CITY OF ALBUQUERQUE

August 7, 2015

Re: Del Webb @ Mirehaven Phase 1
Pad Certification – Lots 47, 162-177
Conditional: Lots 166 through 169
Engineer's Stamp dated: 3-20-14, (H09D017C)
Certification dated: 7-27-15

DESIGN REVIEW COMMITTEE	CITY ENGINEER APPROVAL	LAST DESIGN UPDATE	MO./DAY/YR.	MO./DAY/YR.	
CITY PROJECT NO.	ZONE MAP NO.	SHEET	8	OF	8

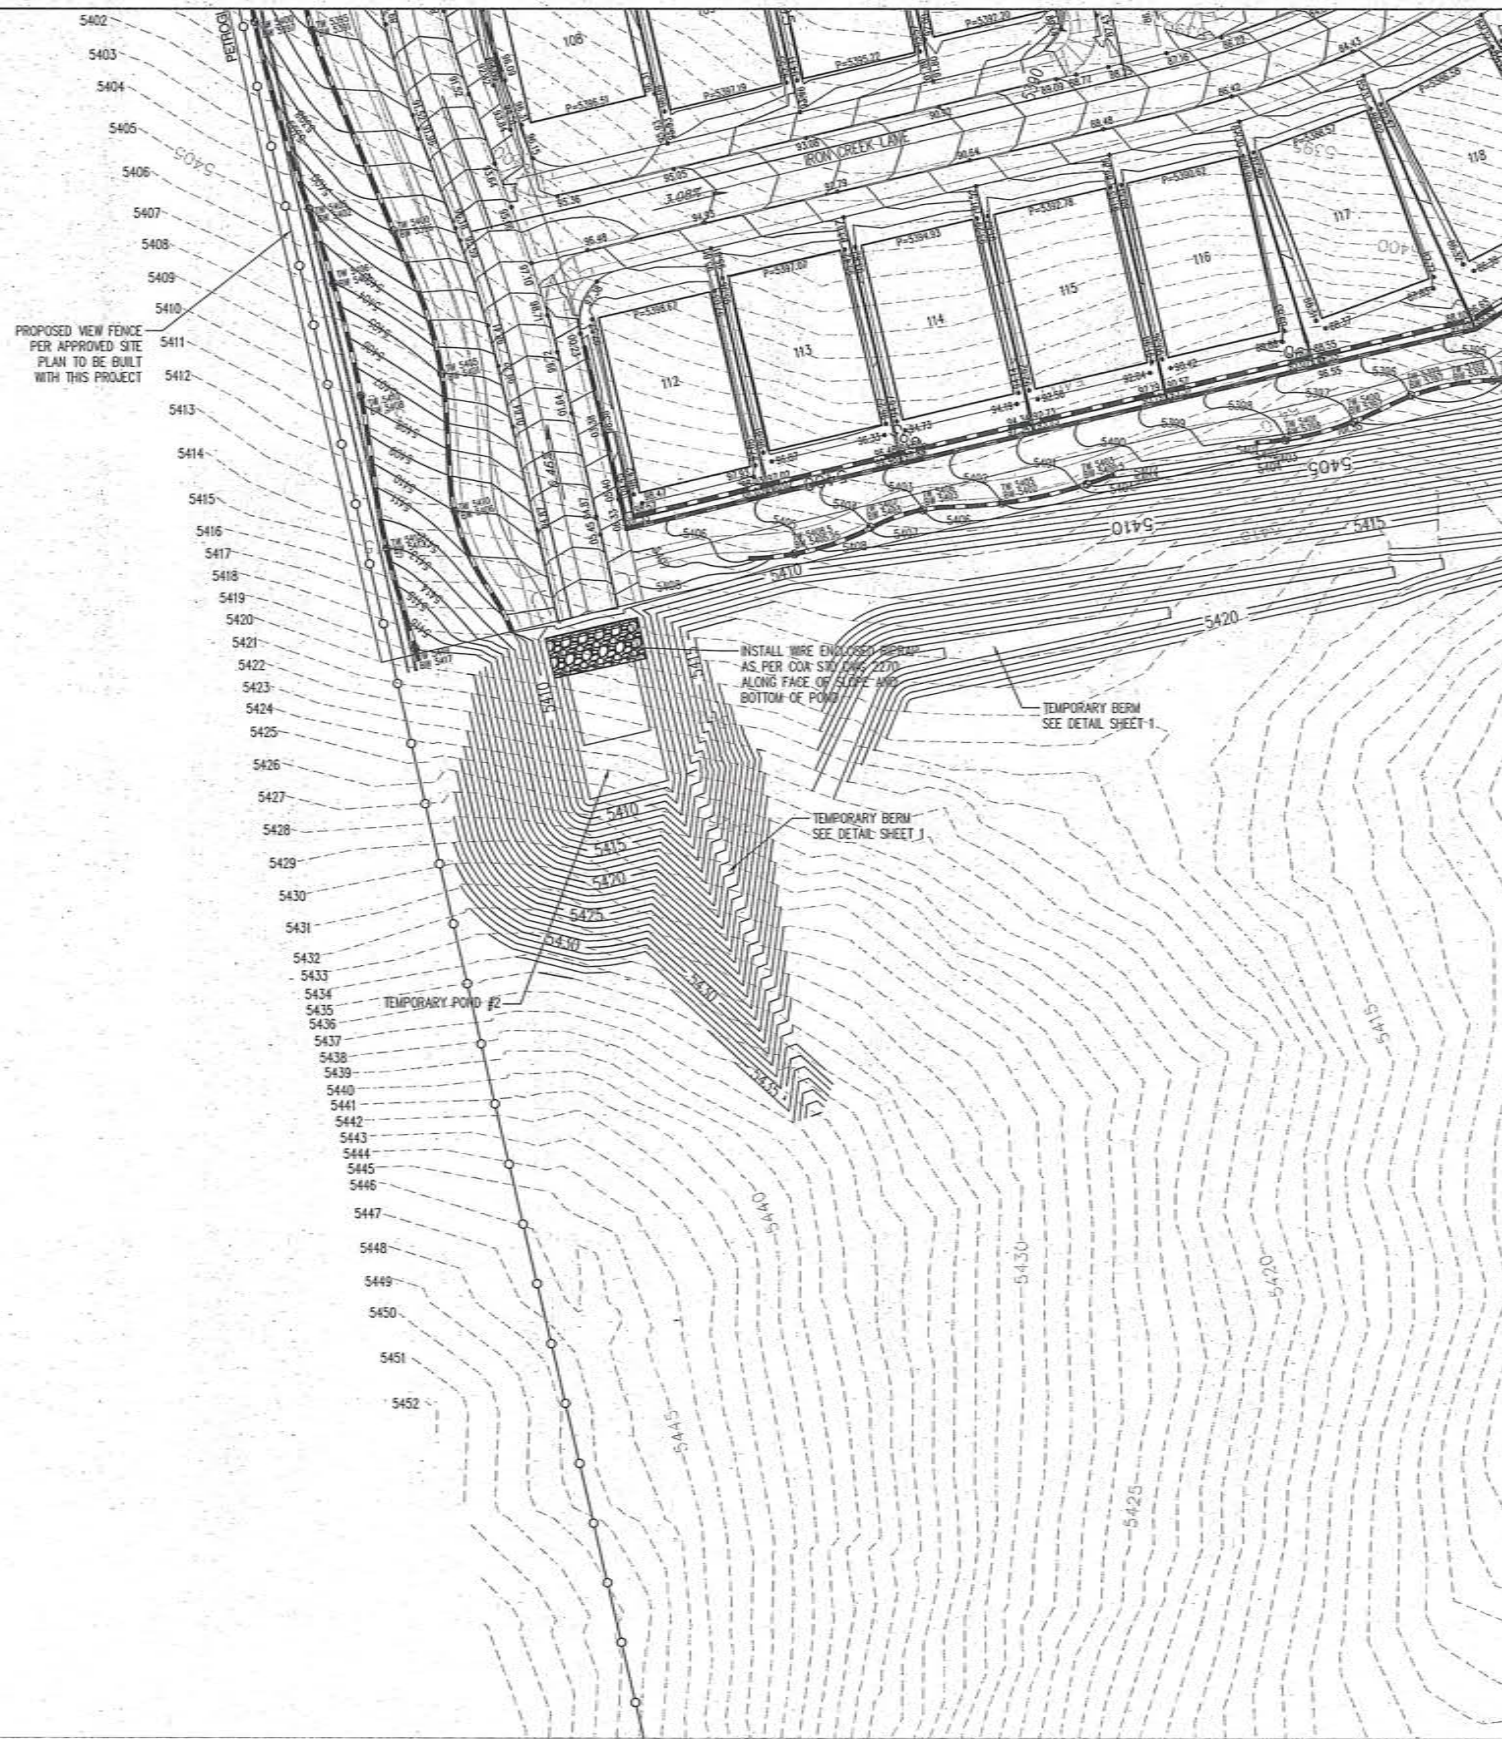
Since Lots 166 through 169 are partially shown on the arroyo side of the Prudent Line, the channel or southern half of the channel is to be constructed prior to obtaining Certificate of Occupancy.
